SLAE response to TR020001-002183-8.30 Trip Distribution Plans

SLAE comment – Ashcroft Road, Wigmore Lane short cut.

Key

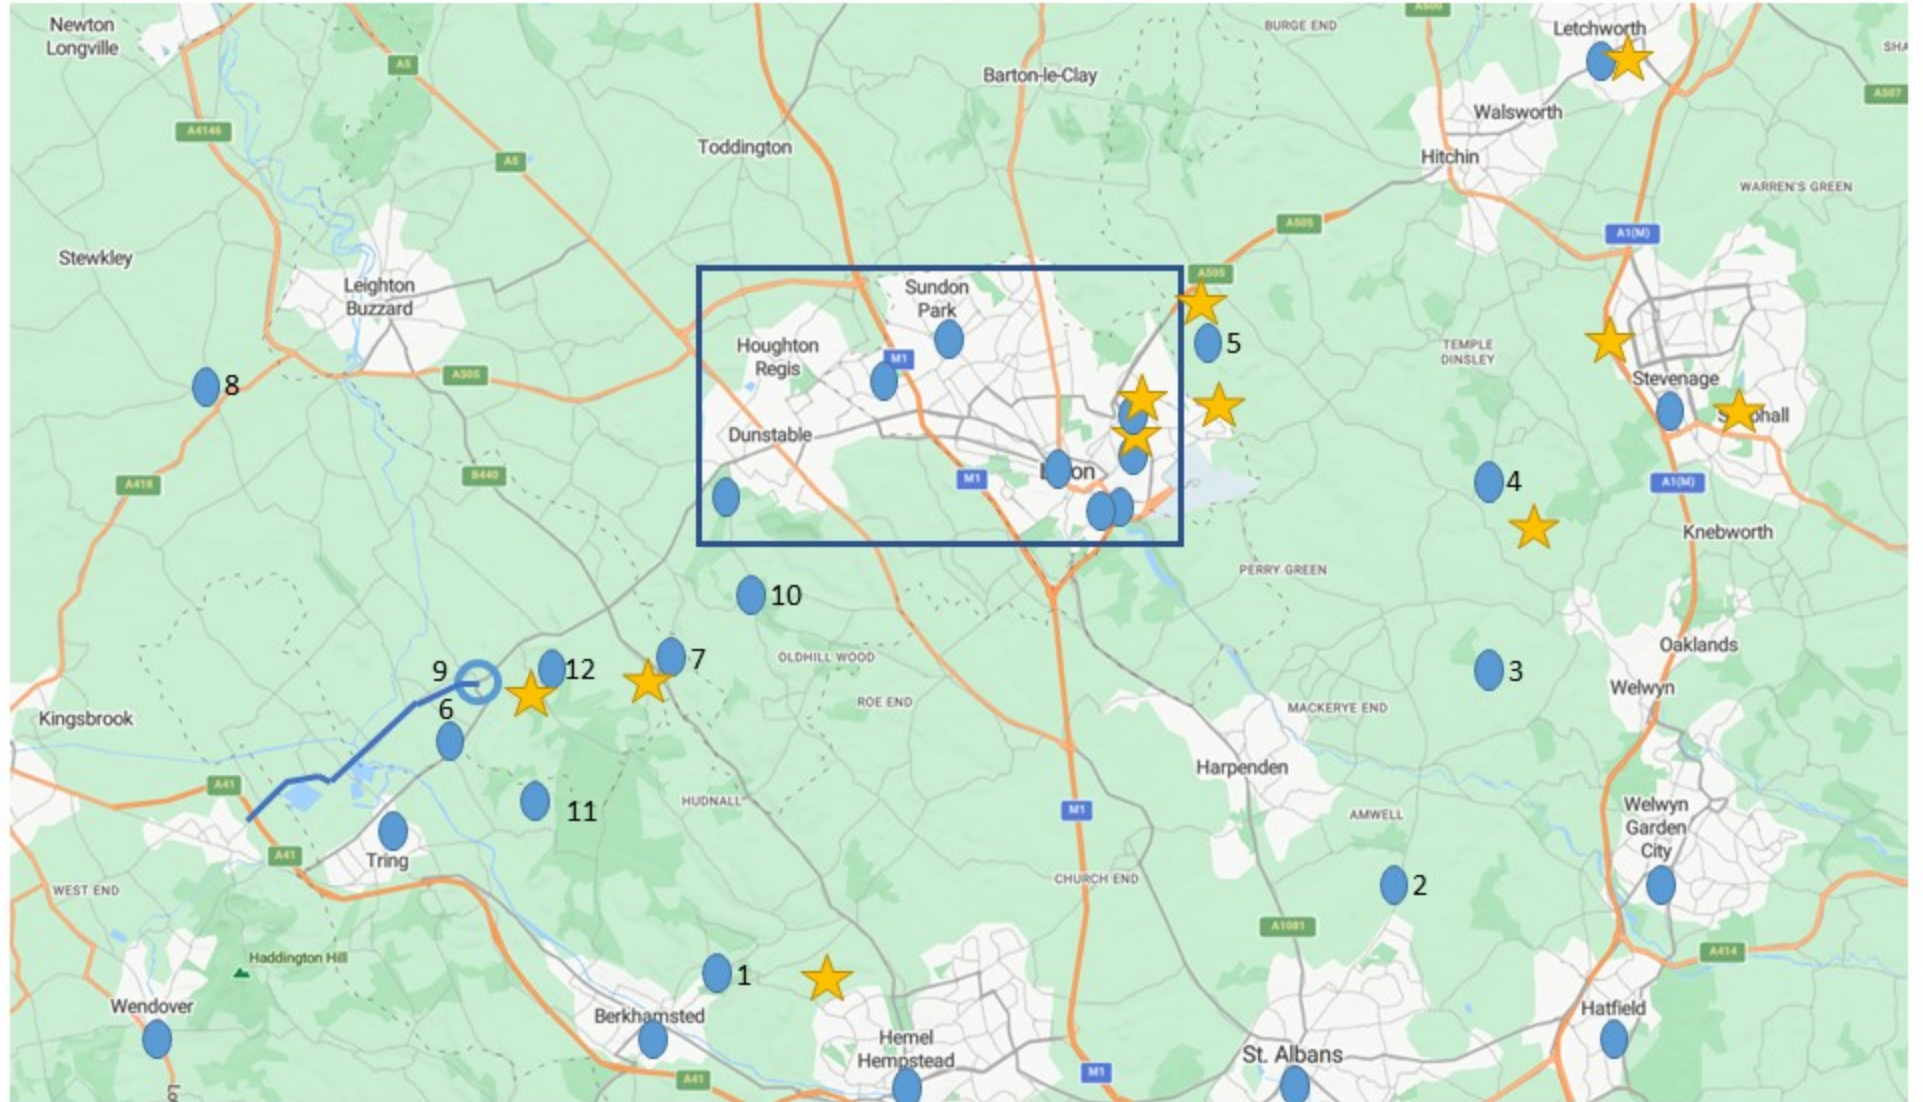
In document (TR020001-001714-8.35 Applicant's Draft Itinerary for the Accompanied Site Inspection), LR asked "However, the purpose for including Ashcroft Road has not been made clear by the Interested Party."

SLAE responded (in TR020001-001765-Stop Luton Airport Expansion - response to document 001714-8.35 Applicant's Draft Itinerary for the Accompanied Site Inspection), with the following explanation. When travelling from the Stopsley roundabout (LU2 7XH), you would turn onto Ashcroft Road, then left onto Wigmore Lane and follow the lane until the Tui roundabout and turn right onto Eaton Green road. It is obvious that unless familiar with the area, a desk bound exercise to find street names may not flag the start of Ashcroft Road. It is a long road and starts near the Stopsley roundabout. Reference (16 on LR's map) gives a false impression of where the road begins.
